CITY OF ALBUQUERQUE

March 13, 2013

Re: The Foothills CLOMR
Engineer stamp date 1-16-13 (E22/D007E)

Based upon the information provided in your submittal received 1-23-13, Hydrology provides the following comments to be addressed prior to submitting the CLOMR:

THE FOOTHILLS MECHENBIER CONSTRUCTION TOPOGRAPHIC WORK MAP

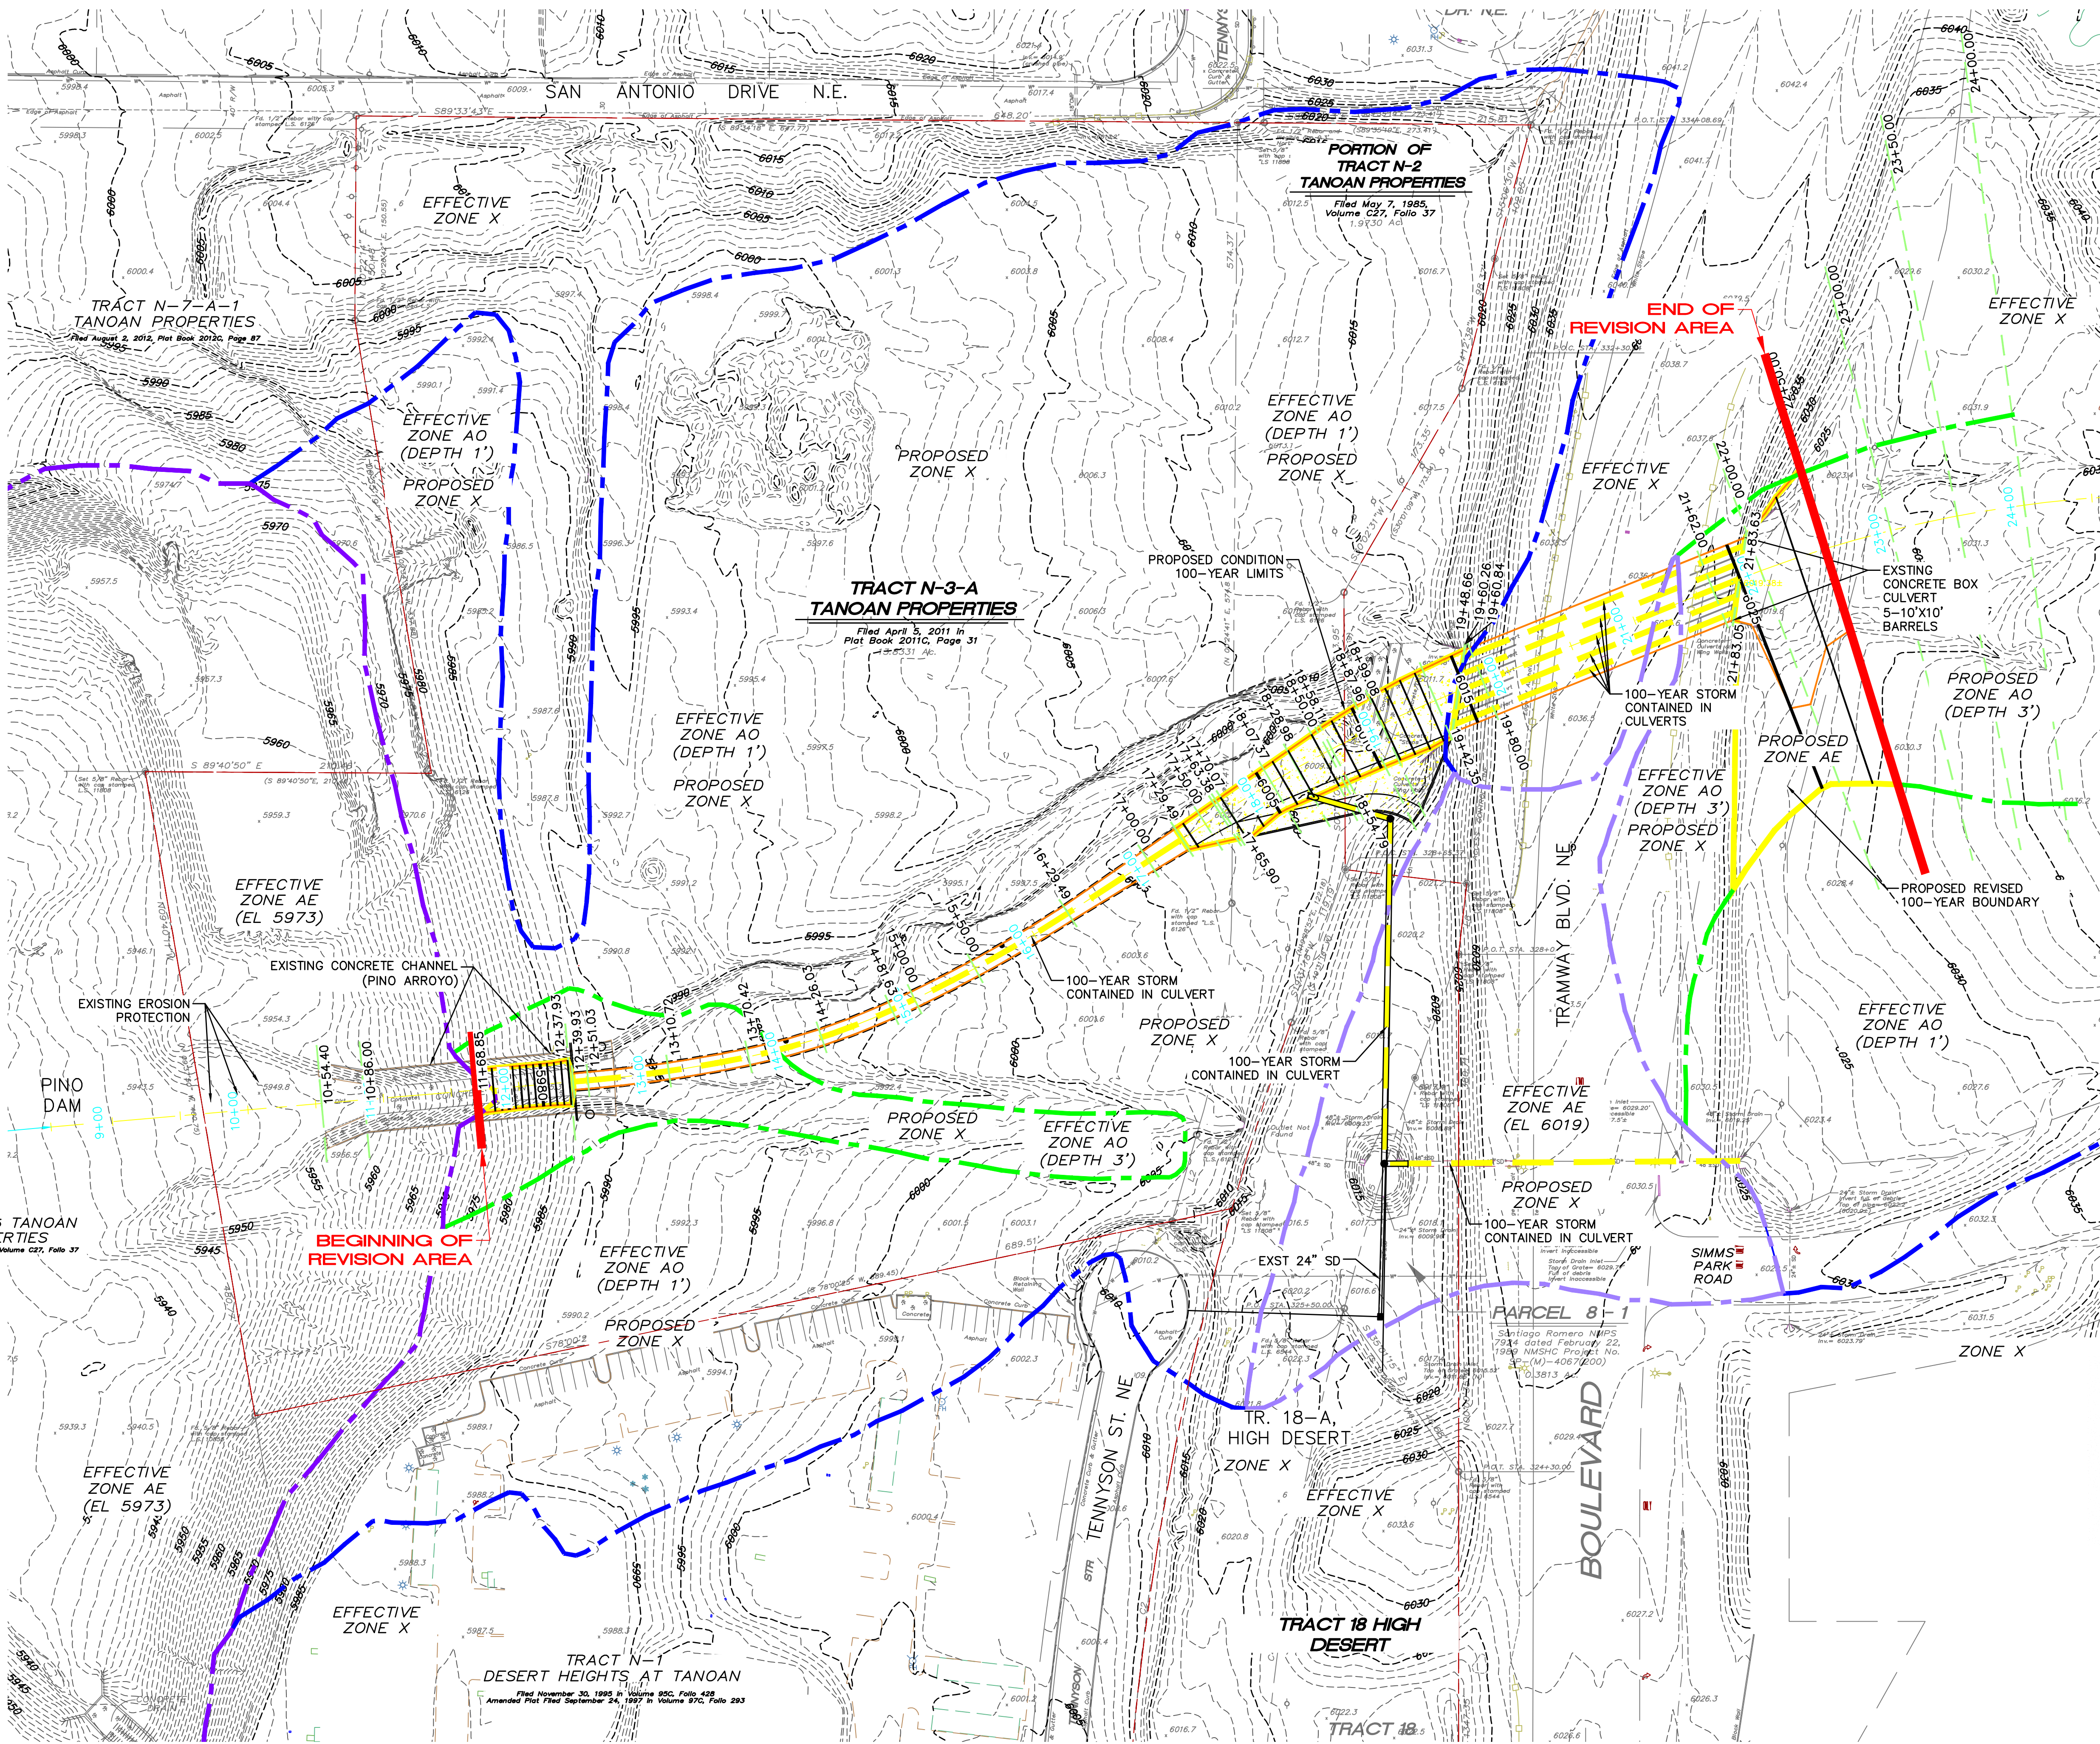
- What is the purpose of including the Memorandum from Craig Hoover of BHI to Sushil Chaudhary at the Dam Safety Bureau?
- A color Topographic Work map (proposed FIRM Revisions Appendix G) is required in the submittal. This map should show the existing and proposed floodplains. I cannot discern the proposed floodplains in this submittal.
